Address: Wood View Farm, Birkby Road, Huddersfield, HD2 2DN

Application number: 2026/92032	
What is the application for?:	Non material amendment to previous permission 2024/92647 for erection of detache
Address of the site or building:	Land at, Occupation Lane, Off Birkby Road, Huddersfield, HD2 2ES
Postcode:	HD3 4EY

Type of comment: An objection	
Do you wish your comments to be published on the website anonymously?	No
FORMAL OBJECTION – APPLICATION 2026/NMA/92032/W I formally object to application 2026/NMA/92032/W being approved as a non-material amendment to permission 2024/62/92647/W. The applicant’s documents state that the dwelling is being reduced so it can be constructed “entirely within the applicant’s legal boundary line”. Drawing AL101a also states that the building setting-out has been changed following “new legal boundary information”. This is significant because I have repeatedly disputed the boundary information relied upon for the original permission. It appears that the approved development could not be constructed as originally positioned without potentially extending outside the applicant’s lawful boundary. I specifically object to drawing 24.002/(EX)01, “Site P

Drawing no
24.002/ (AL)03

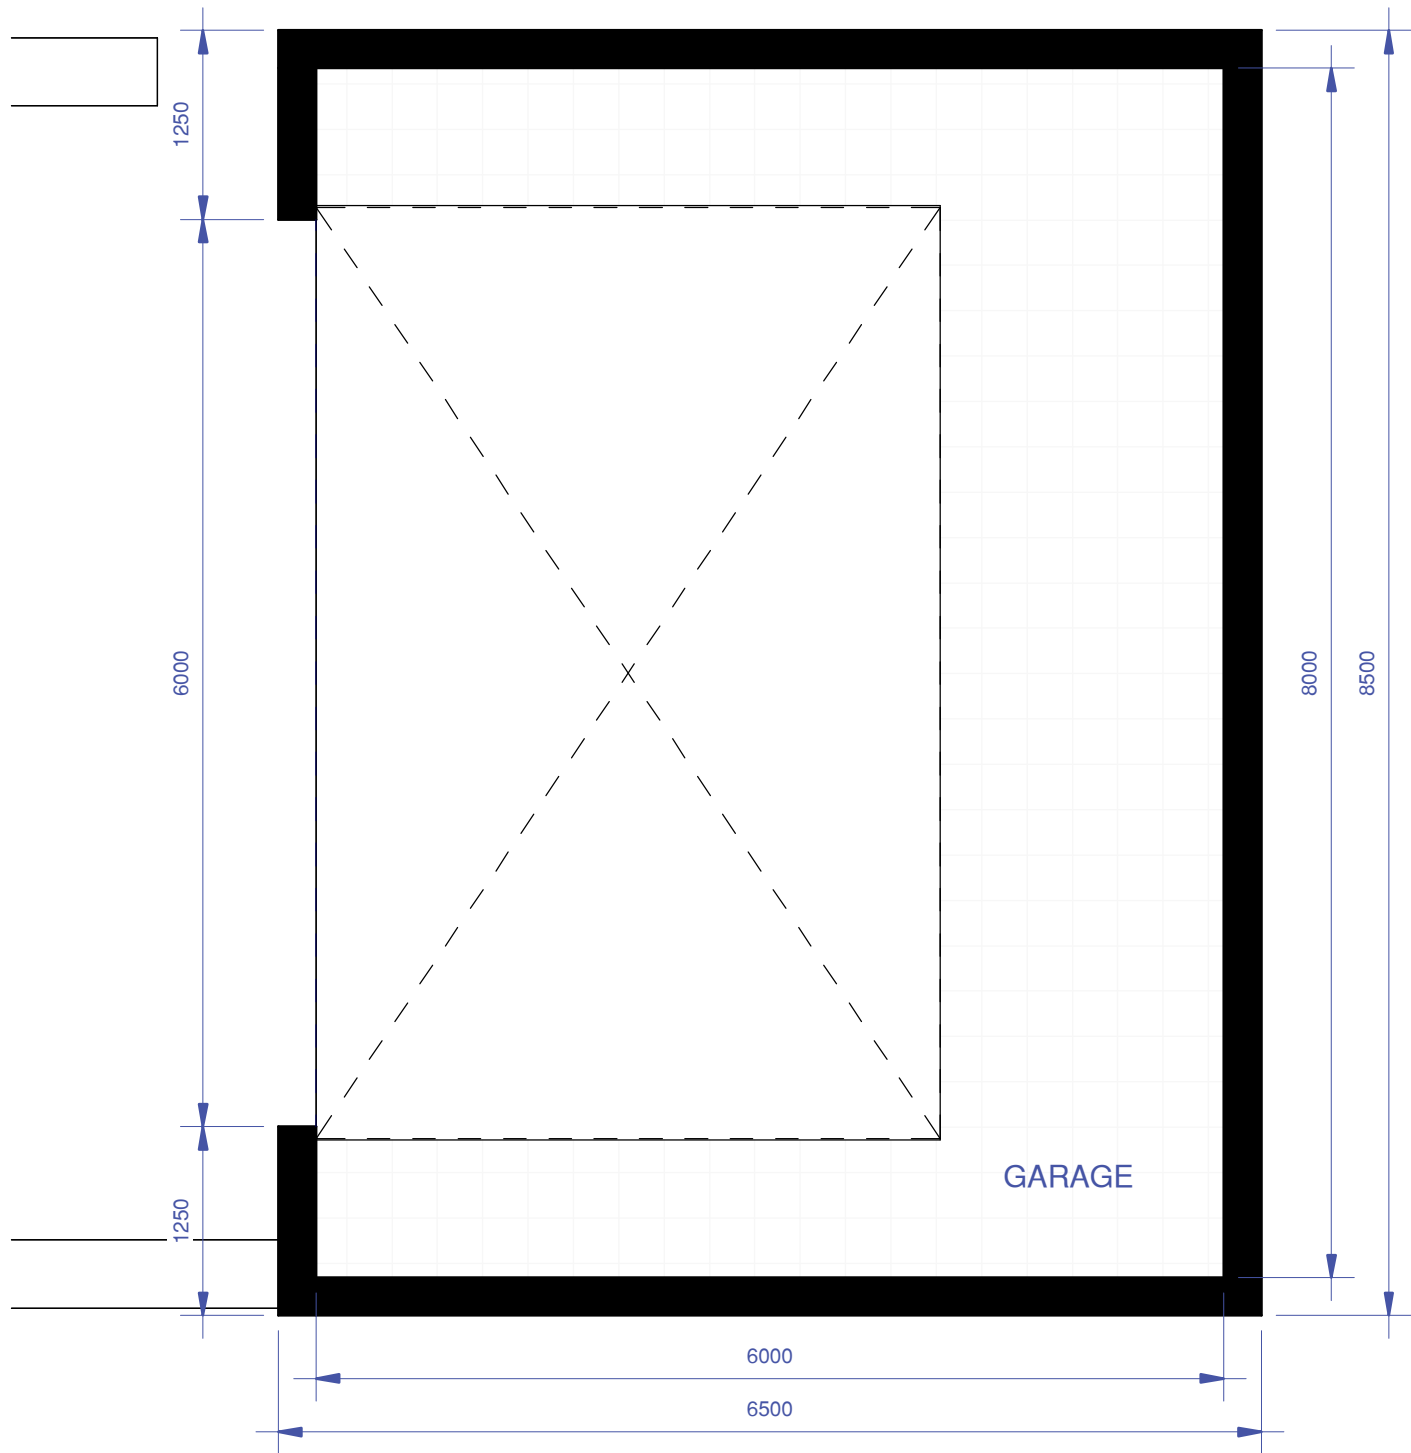
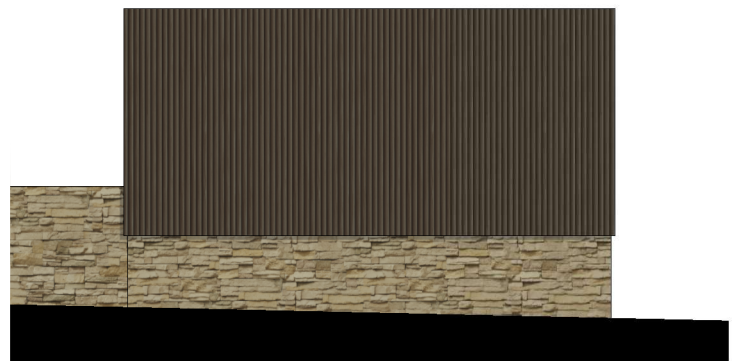
The amendment is also not limited to a minor internal or cosmetic alteration. It changes the dwelling’s footprint and setting-out and relocates and substantially enlarges the garage. The approved garage measured approximately 6.5m by 6.5m, whereas the amended garage measures approximately 6.5m by 8.5m—an increase of approximately 13 square metres, or 31%. The parking, garden and overall site arrangement are also changed.

Drawing no
Site Plan as Proposed

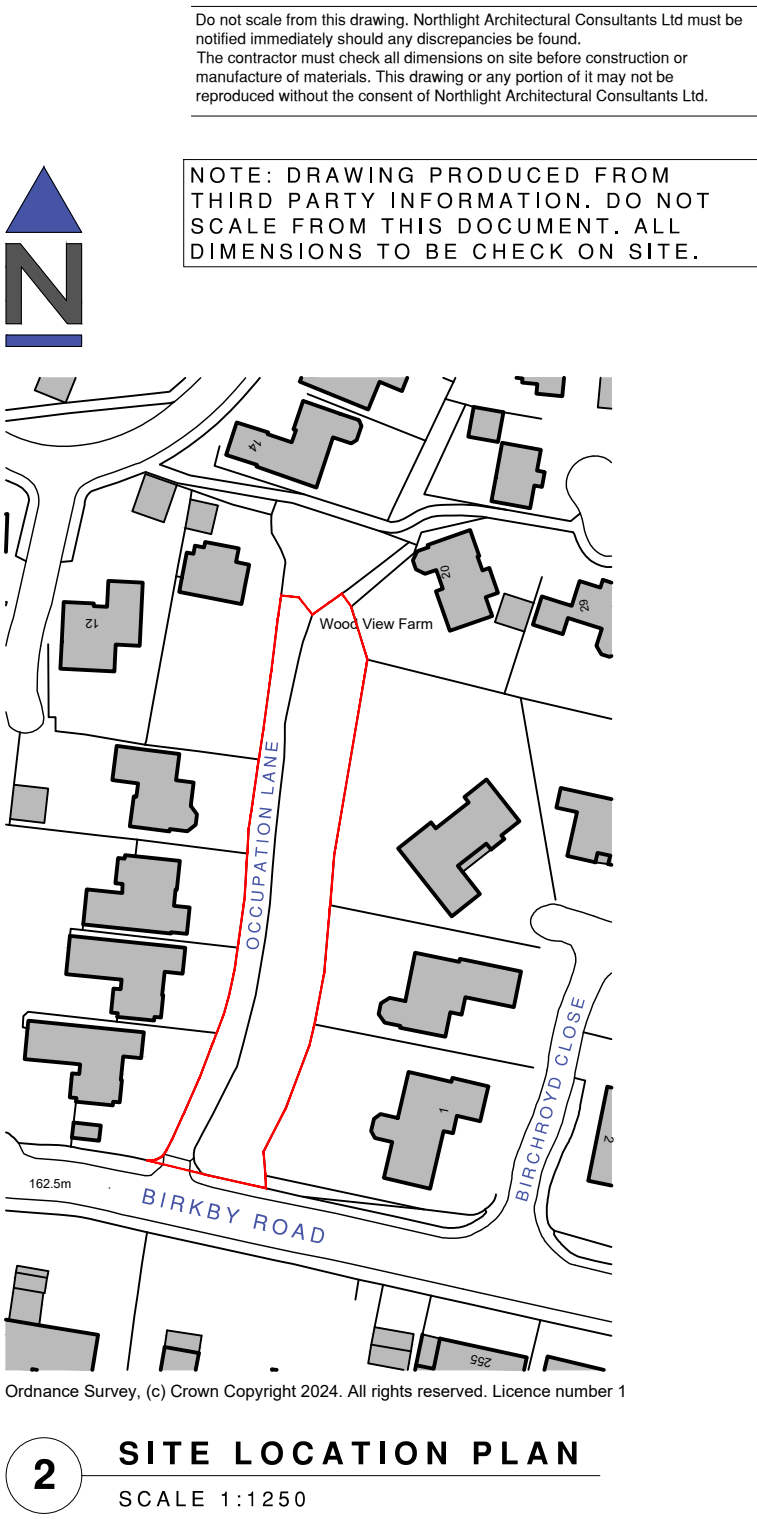
- my sole driveway and legal access;
- emergency and service-vehicle access;
- the boundary wall and stability of land beside the excavation;
- underground services and drainage;
- privacy and residential amenity;
- the future use and development of my property; and
- the possibility of construction taking place on or affecting third-party land.

Drawing title
Bungalow Floor & Roof Plans as Proposed

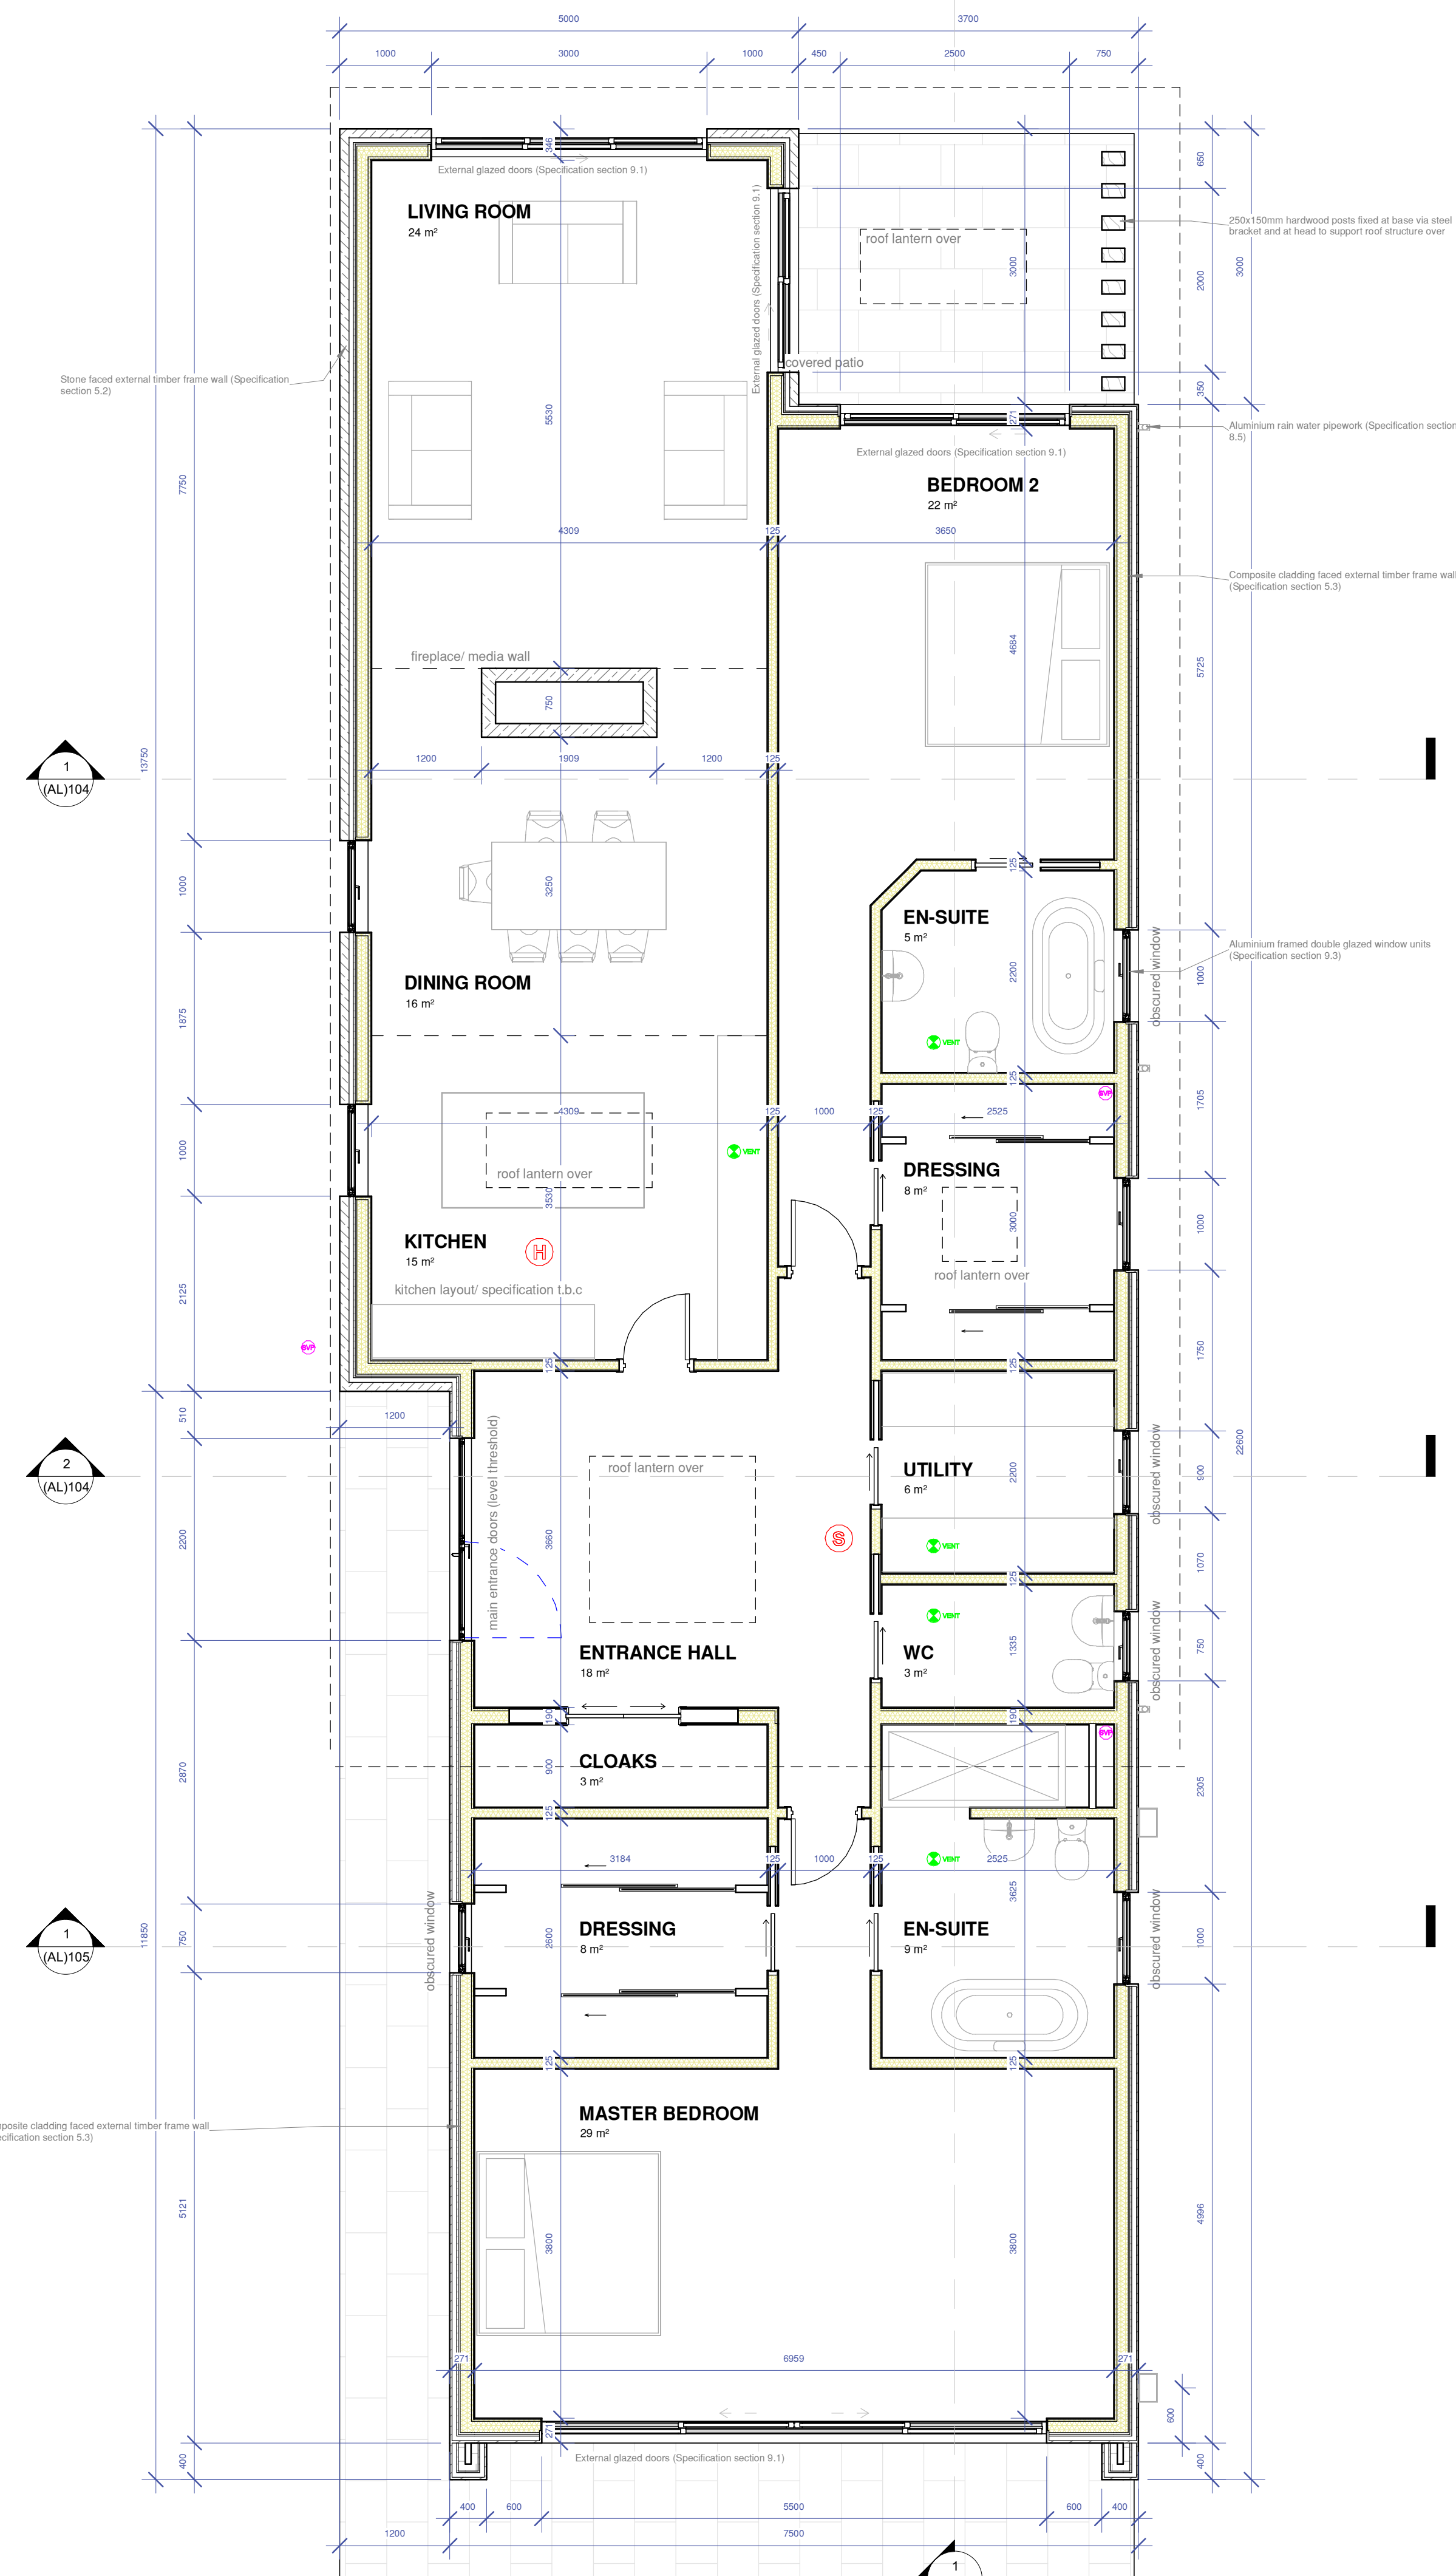
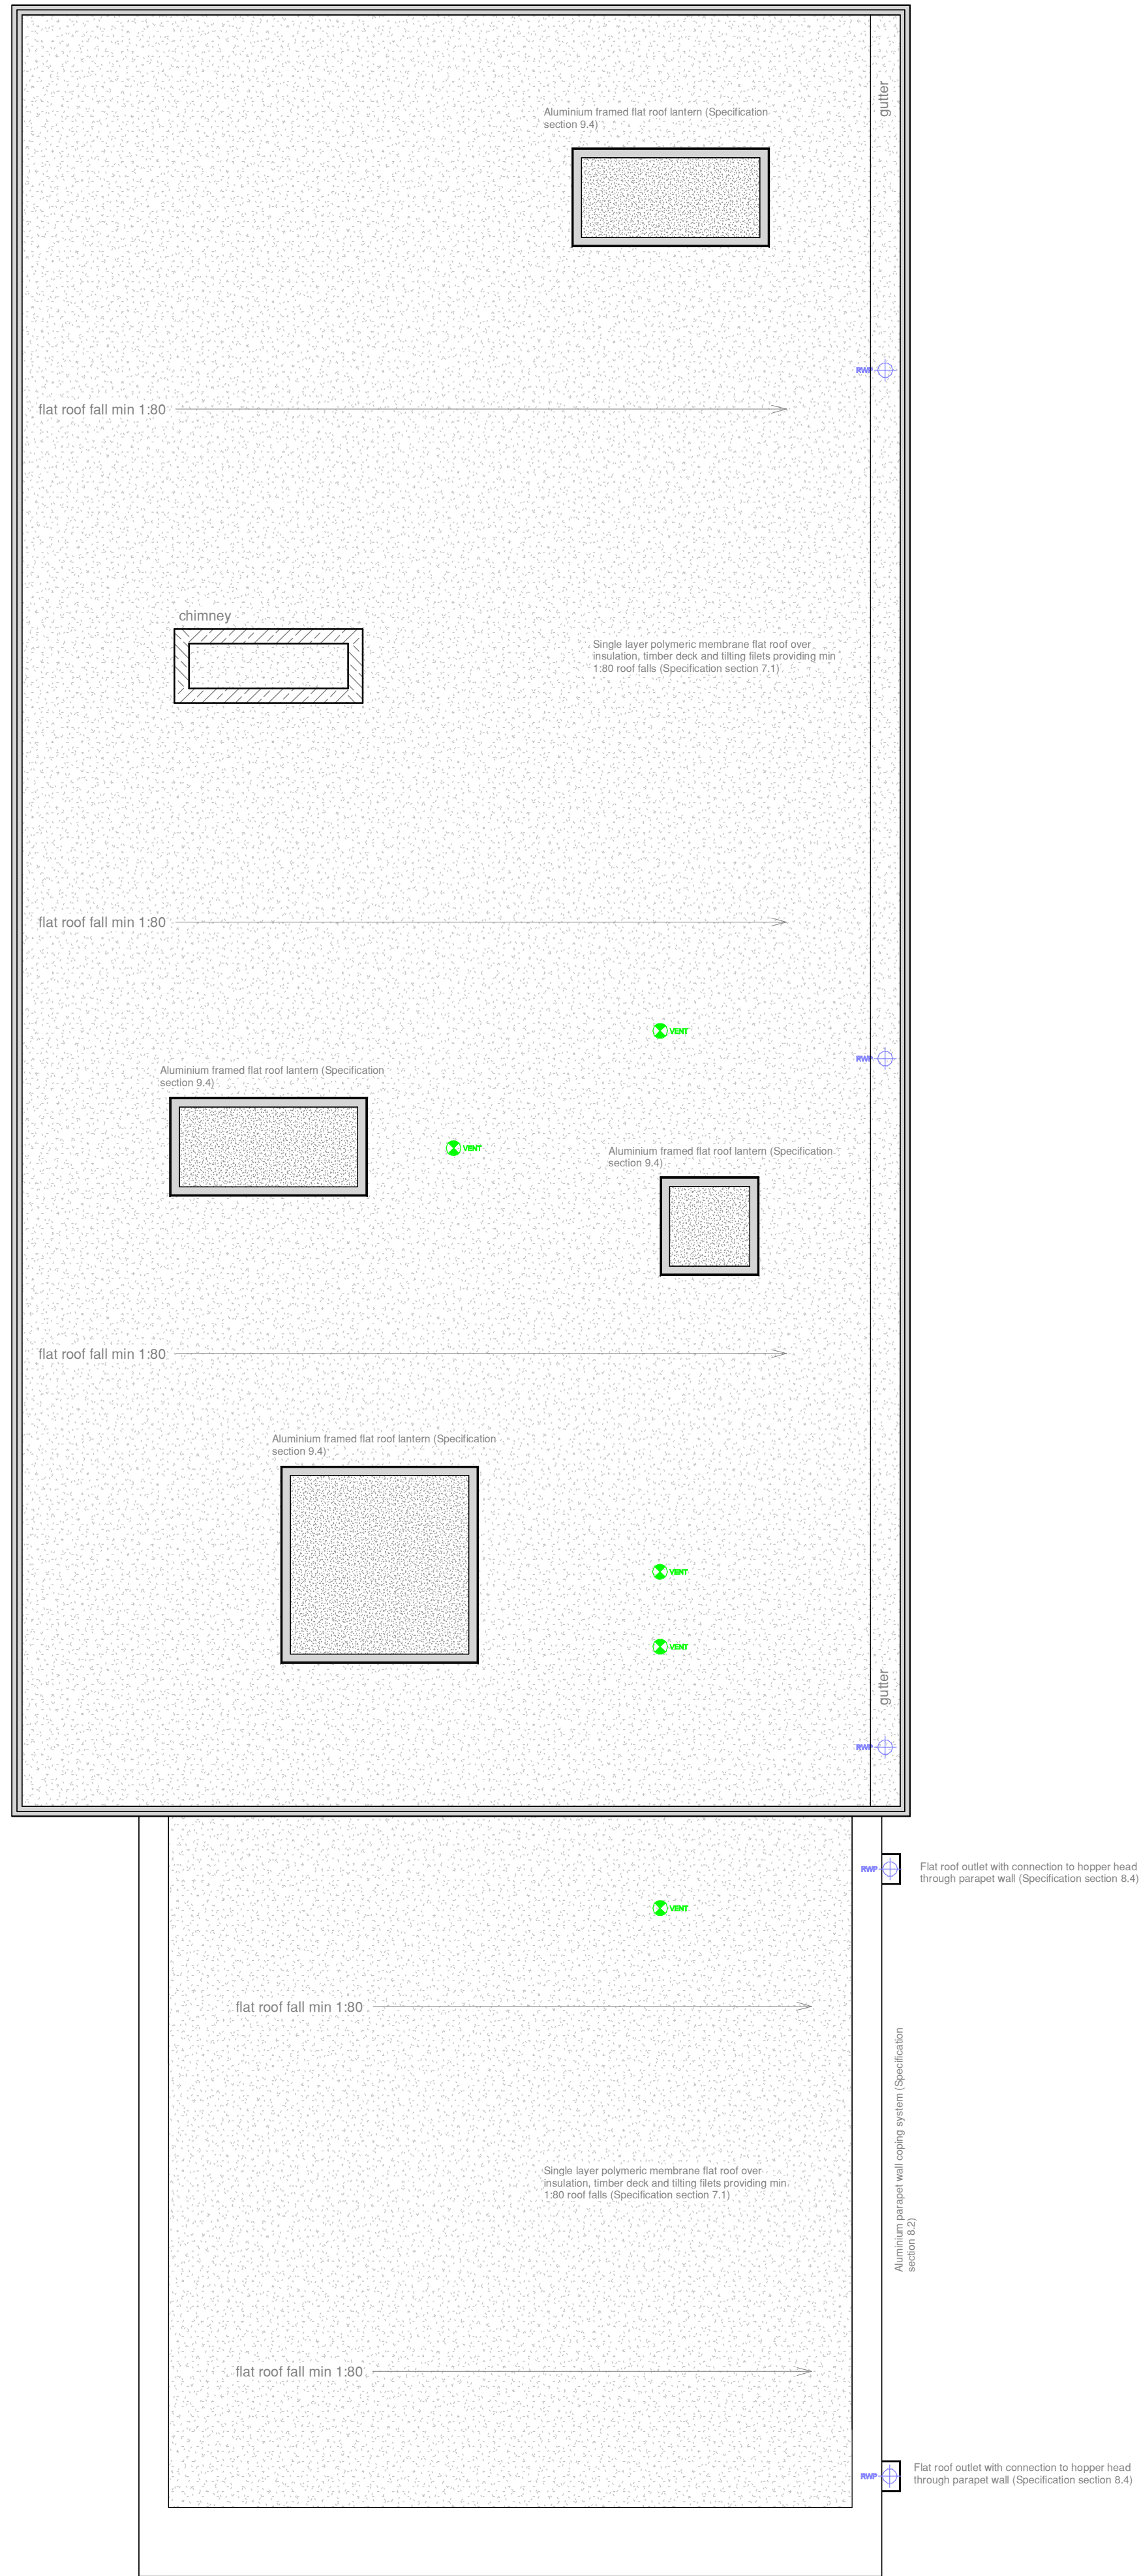
because of new legal boundary information. A plan based on unidentified third-party information, dated July 2024 and marked “do not scale” cannot reliably establish the current legal boundary.
